# CITY OF ALBUQUERQUE

**Re: Daycare Center  
515 Old Coors Dr. SW  
30-Day Temporary Certificate of Occupancy- Transportation Development  
Transportation Development Final Inspection  
Architect's Stamp dated 12-05-16 (K11-D086)  
Certification dated 11-30-17**

SITE PLAN / TRAFFIC CIRCULATION LAYOUT
SCALE: 1/8" = 1' - 0"

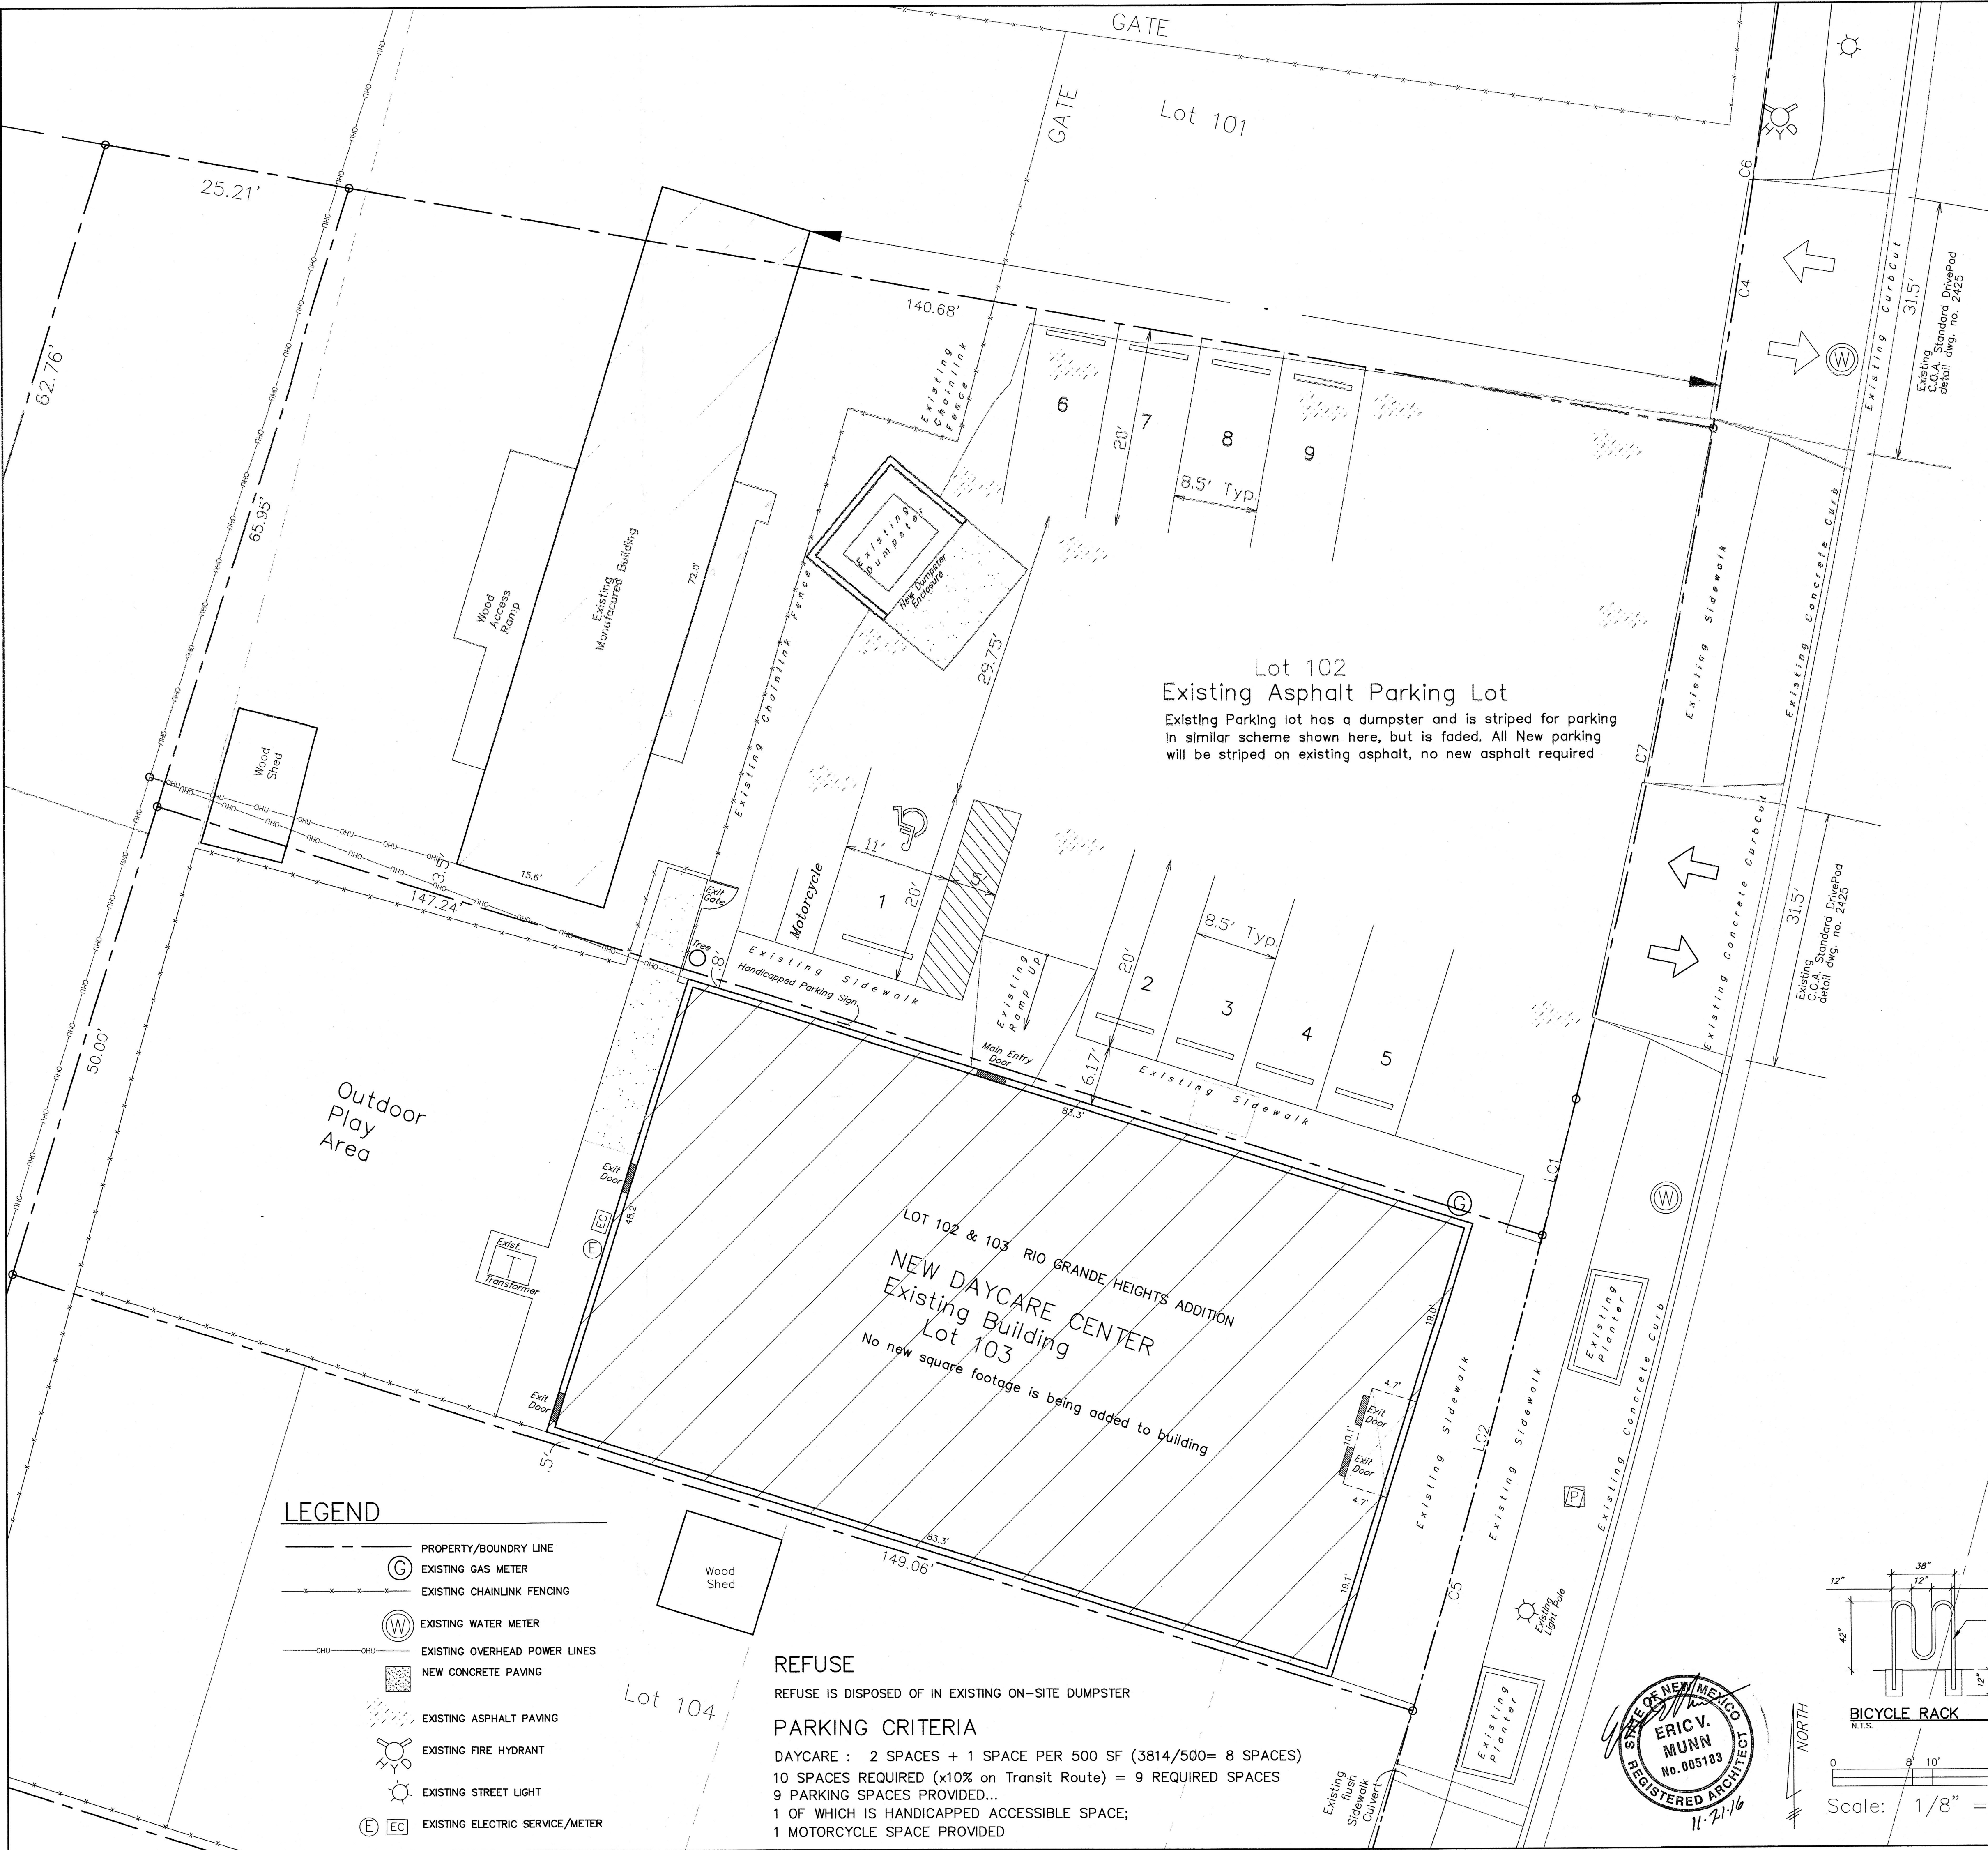
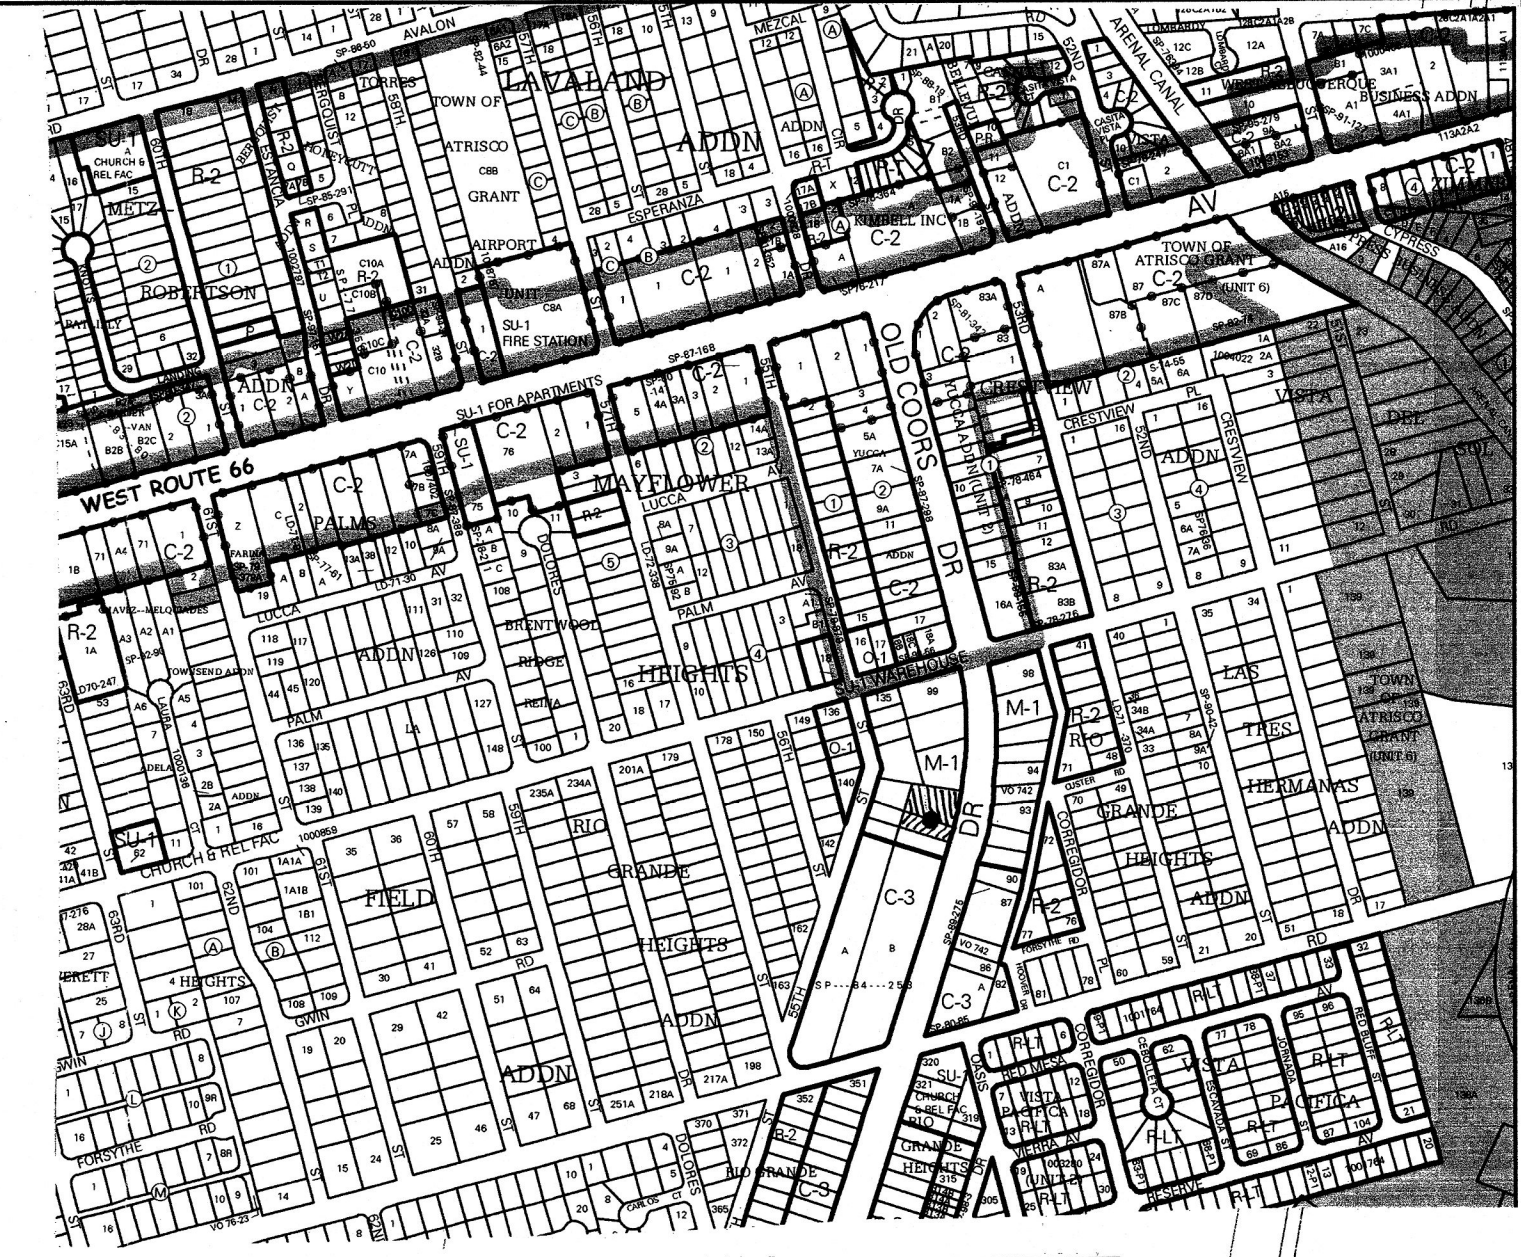
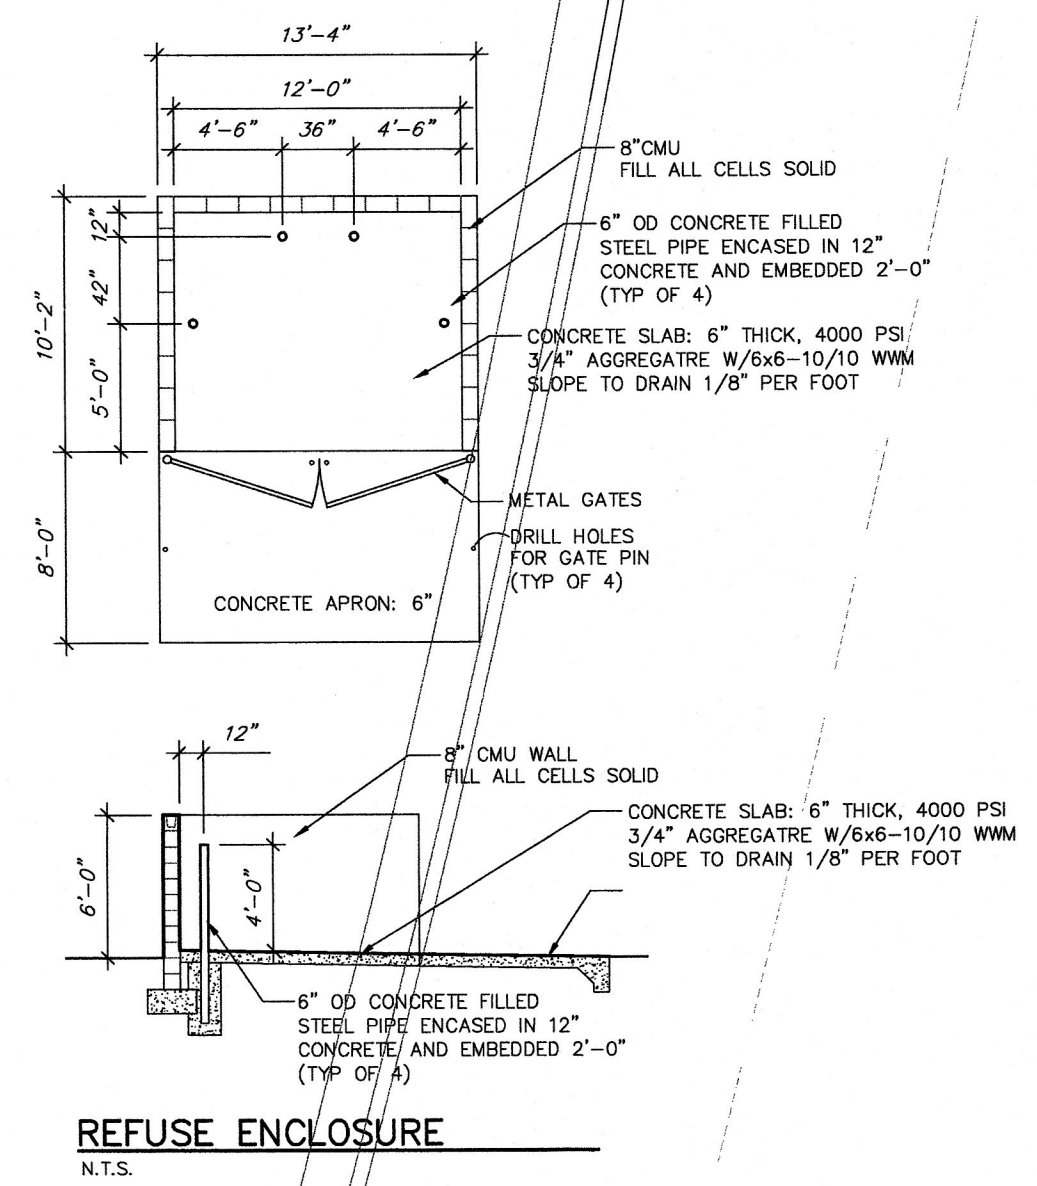
1. Motorcycle parking spaces must be designated by its own conspicuously posted upright sign, either free-standing or wall mounted per the zoning code.
